Appeal Decision

Decision date: 01 April 2020

Appeal Ref: APP/C3810/W/19/3243339
54 Arundel Road, Littlehampton BN17 7DD

- The appeal is made under section 78 of the Town and Country Planning Act 1990 against a refusal to grant planning permission.
 - The appeal is made by C Houston of Haven Sent Properties Ltd against the decision of Arun District Council.
 - The application Ref LU/125/19/PL, dated 15 April 2019, was refused by notice dated 19 September 2019.
 - The development proposed is demolition of 3 no. garages and erection of 7 room HMO with shared facilities and parking for 3 cars.
-

FLANK (EAST) ELEVATION

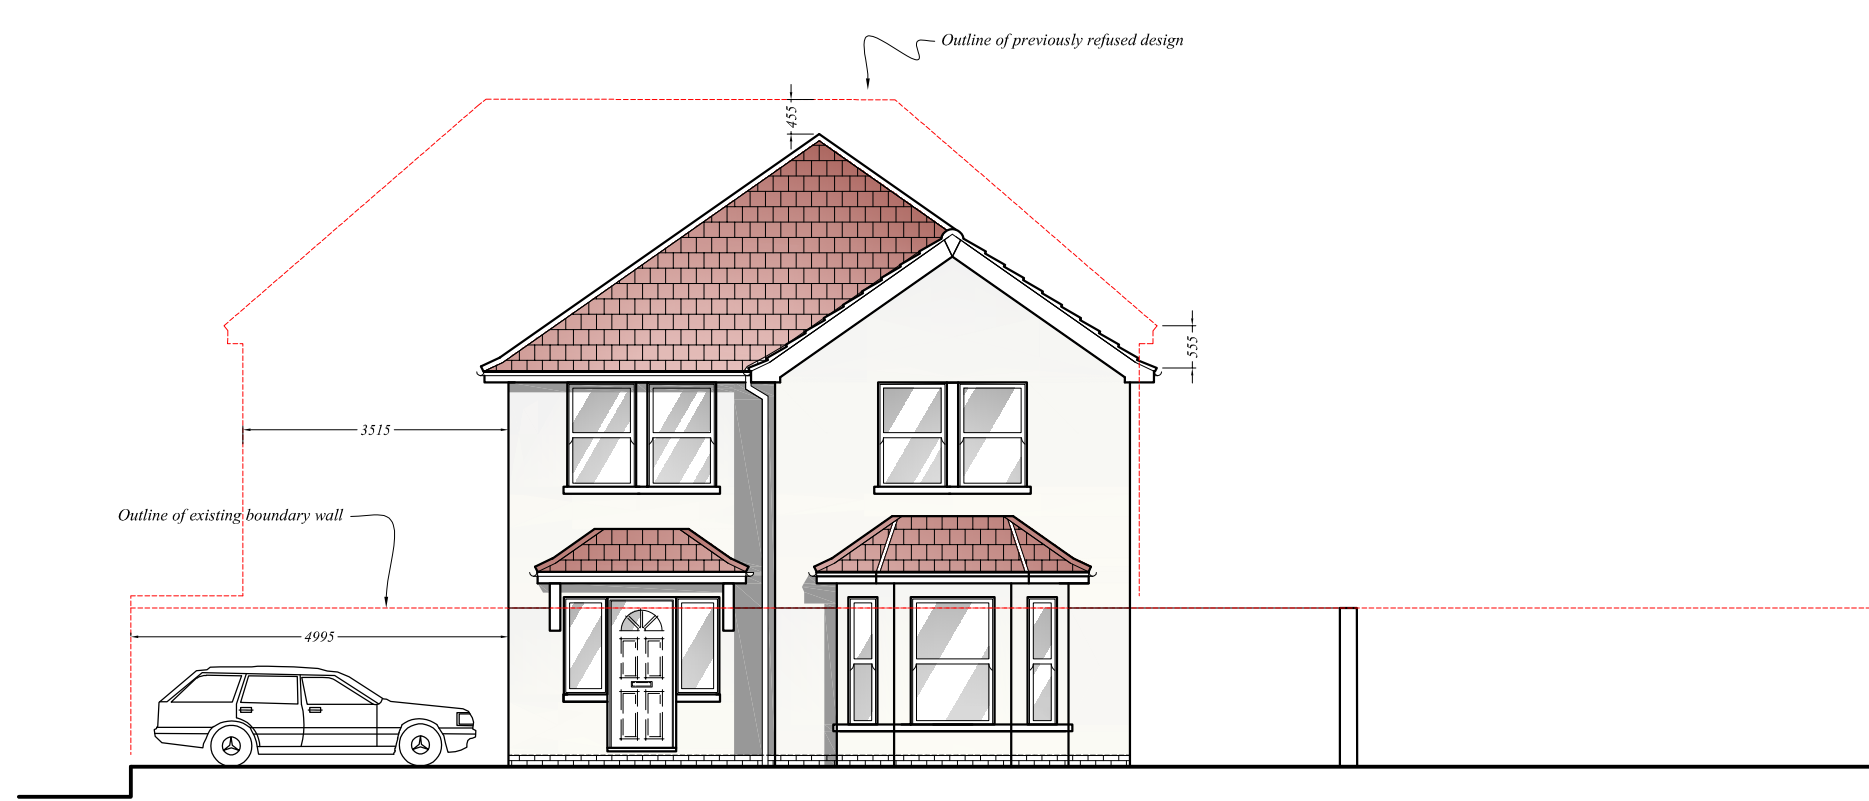
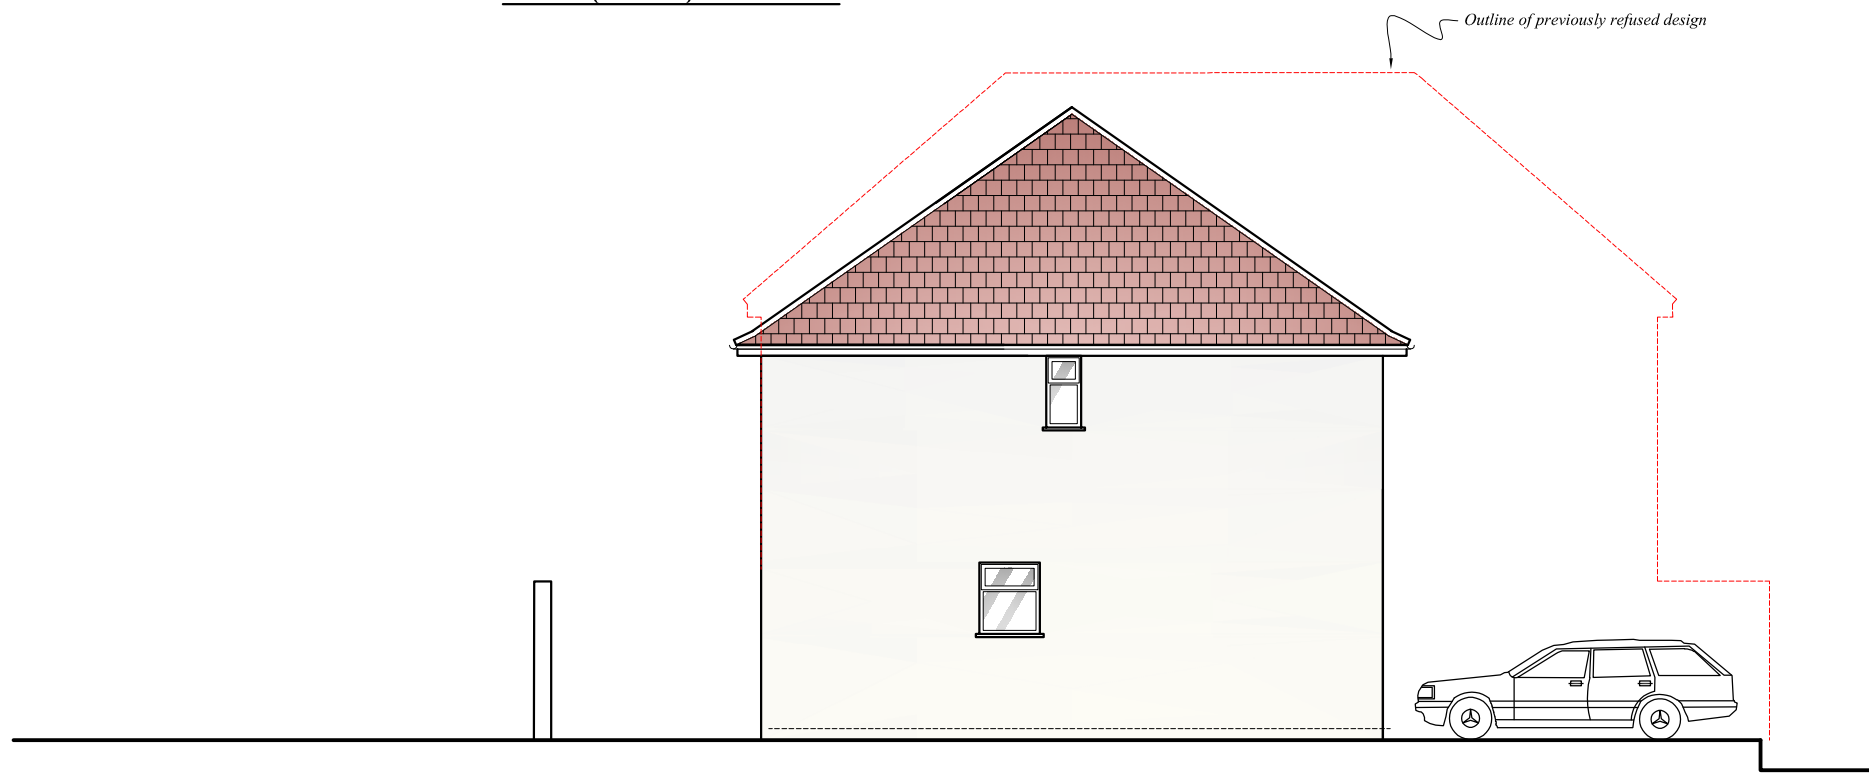
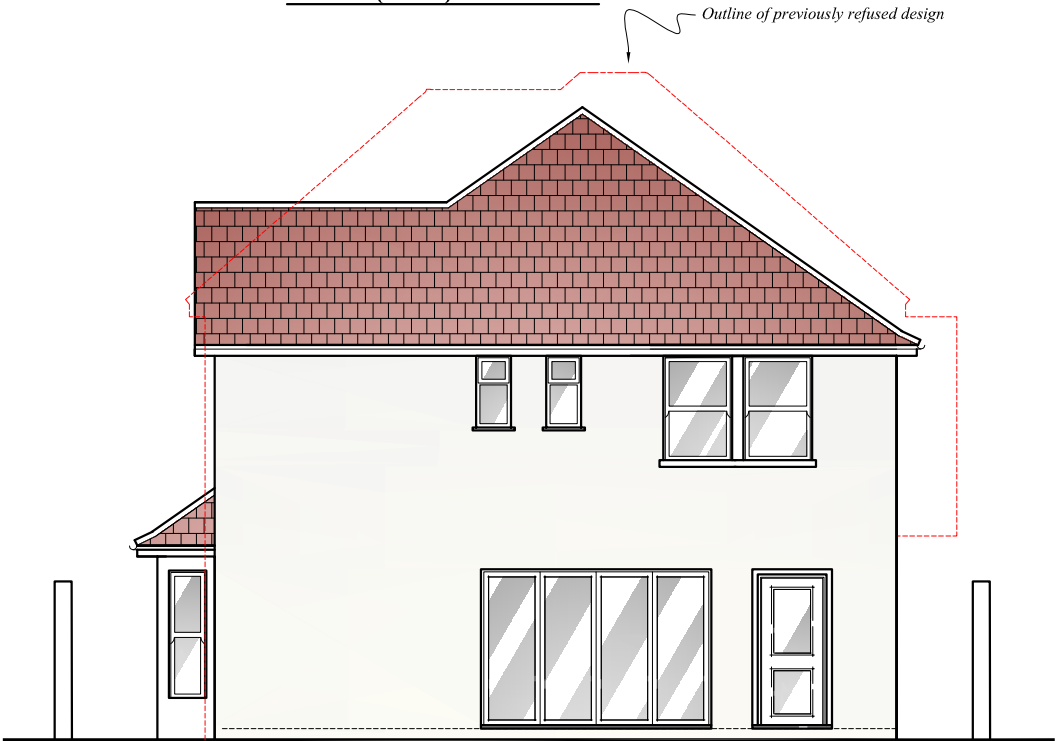
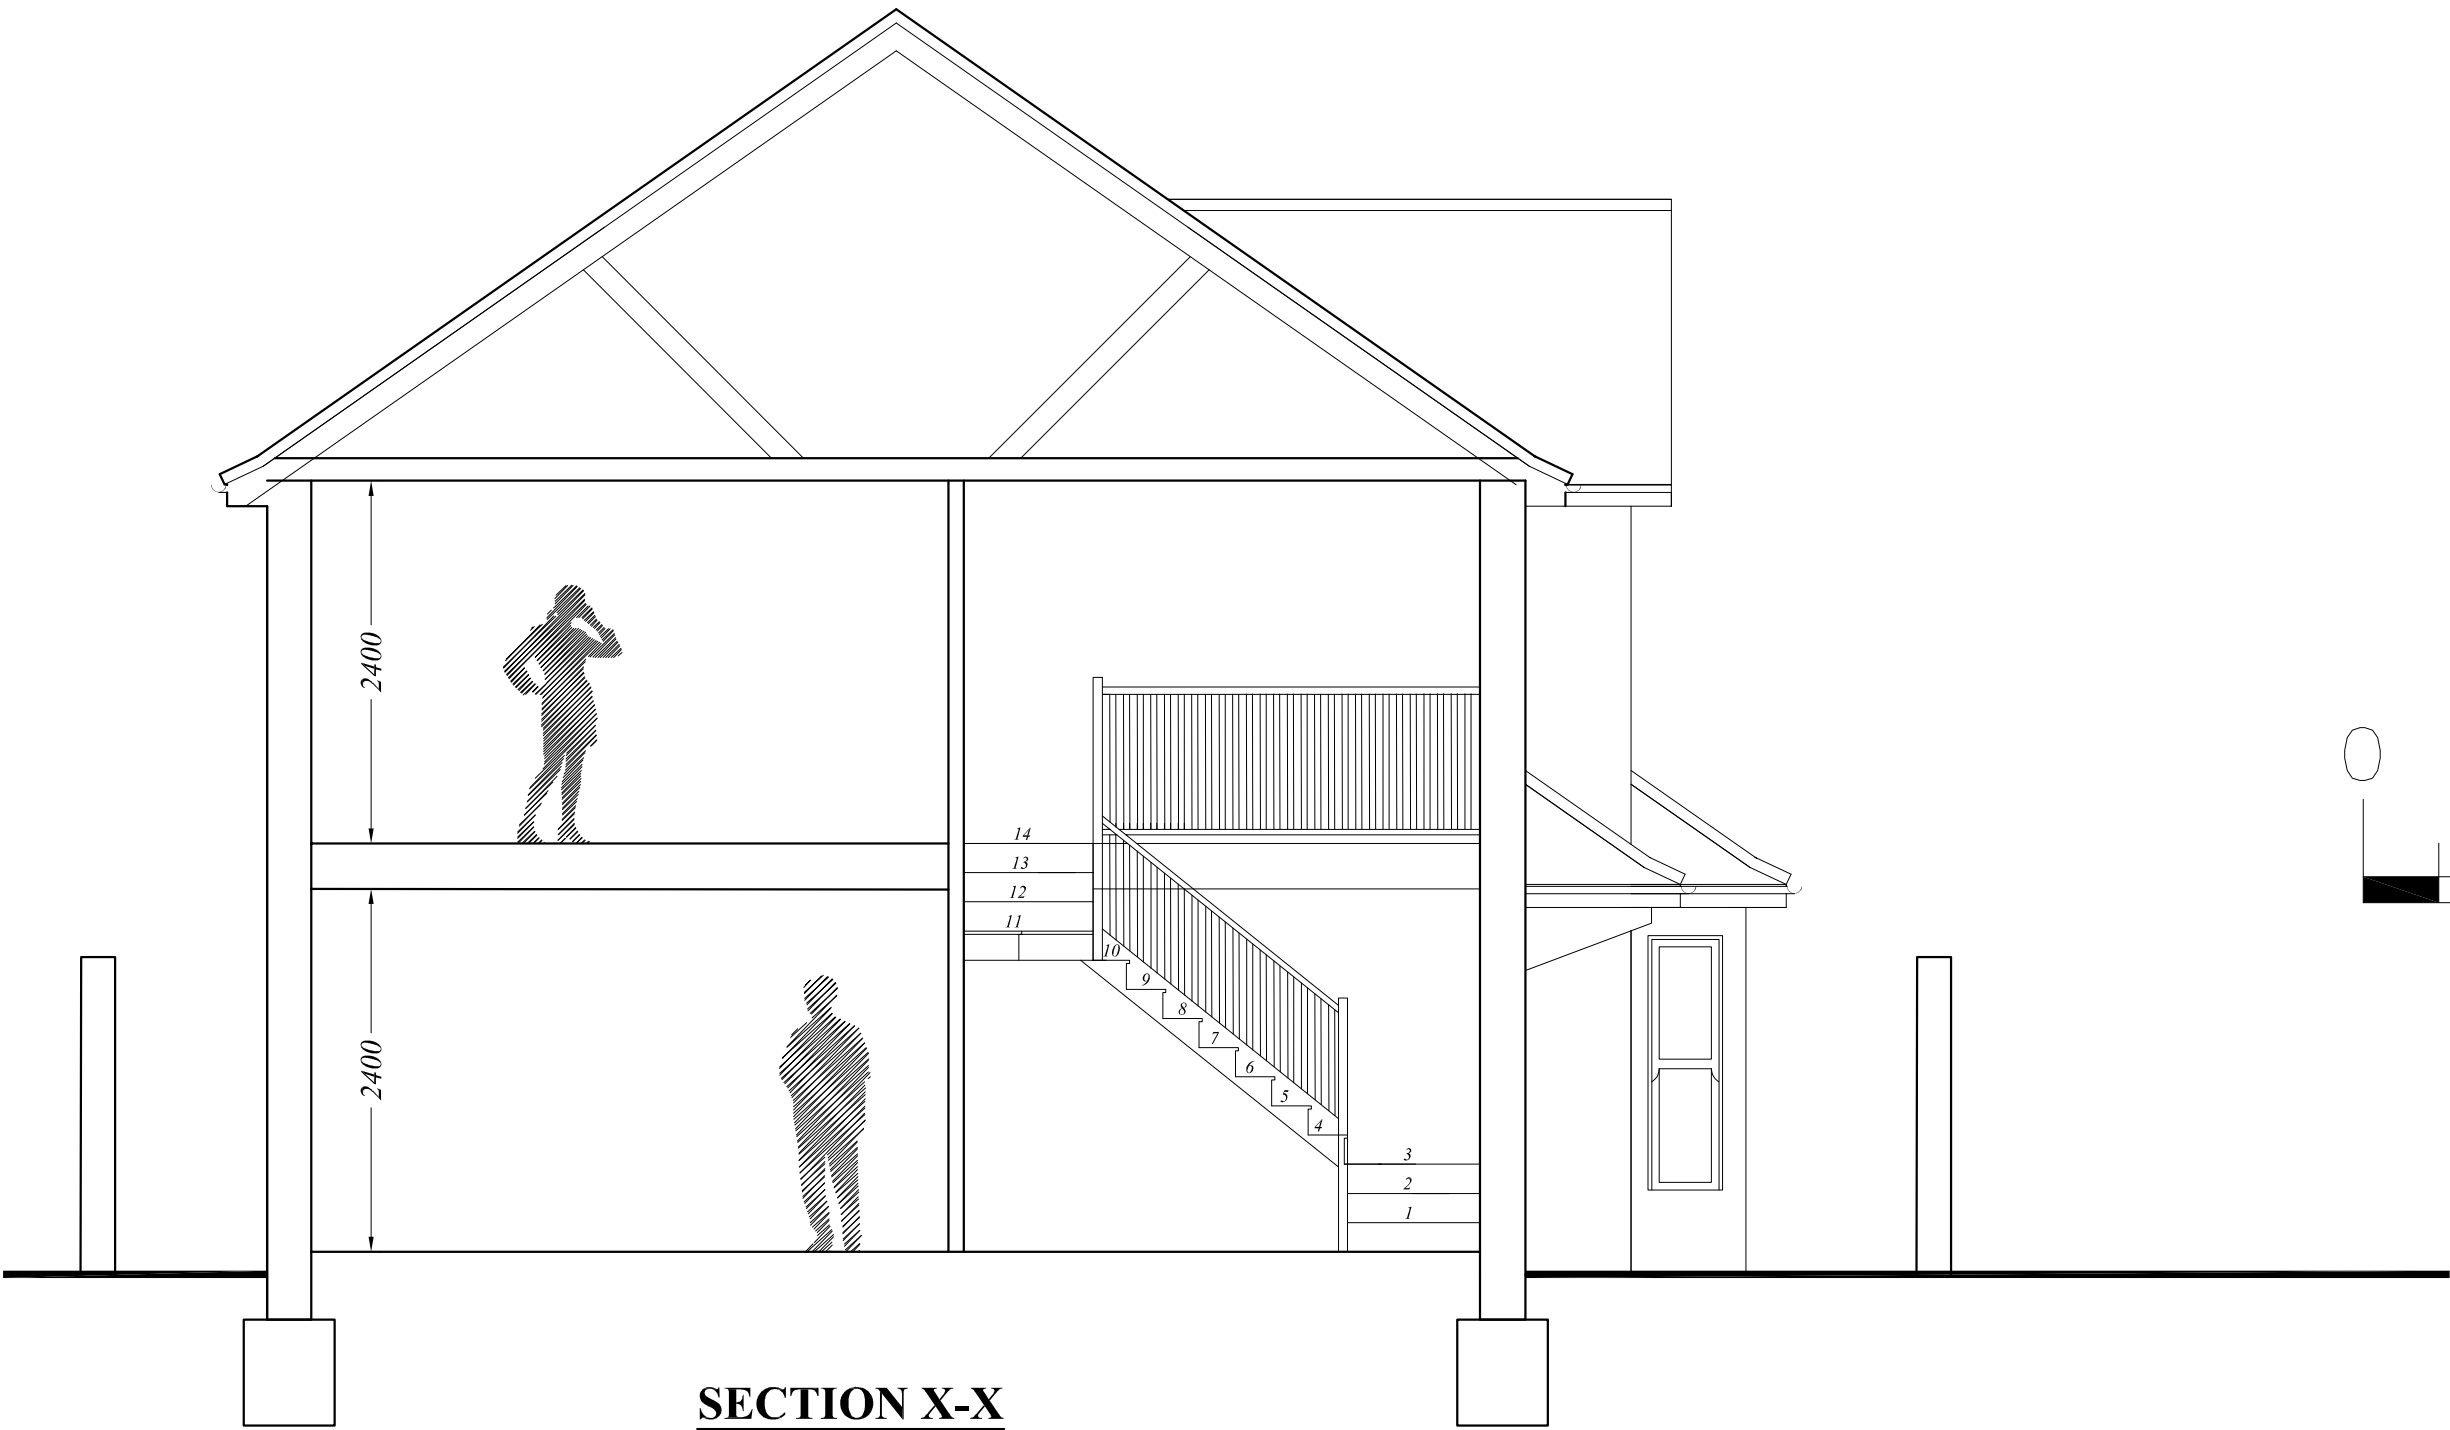
10. At its closest the separation distance between the east elevation of the proposed building and the ground floor and first floor windows in the side elevation of No 1 York Road would be approximately 9.0 metres. Similarly, at its closest the west elevation of the proposed building would be approximately

10.5 metres from the ground floor and first floor windows in the rear elevations of Nos 52 and 54 Arundel Road.

11. Taking into account the separation distances and scale of the proposed building, it would be dominant and overbearing upon the outlook from the side elevation windows of No 1 and rear elevation windows of No 54. For the same reasons, and as a result of its position being to the west of No 1 and to the east of No 54, the proposed building would have a shading effect on No 1 during the afternoon and No 54 during the morning, thus reducing the amount of sunlight reaching these properties.

14. However, whilst two of the windows at first floor level serving habitable rooms would be at a high level, there would also be narrow full-length windows positioned within protruding bays in the east and west elevations of the proposed building. Given the position of the proposed full-length windows and the degree to which they would look towards the side elevation windows of No 1 and the rear elevation windows of Nos 52 and 54 and their respective rear gardens, the proposal would result in a significant loss of privacy to the occupiers of No 1 and Nos 52 and 54 due to overlooking.
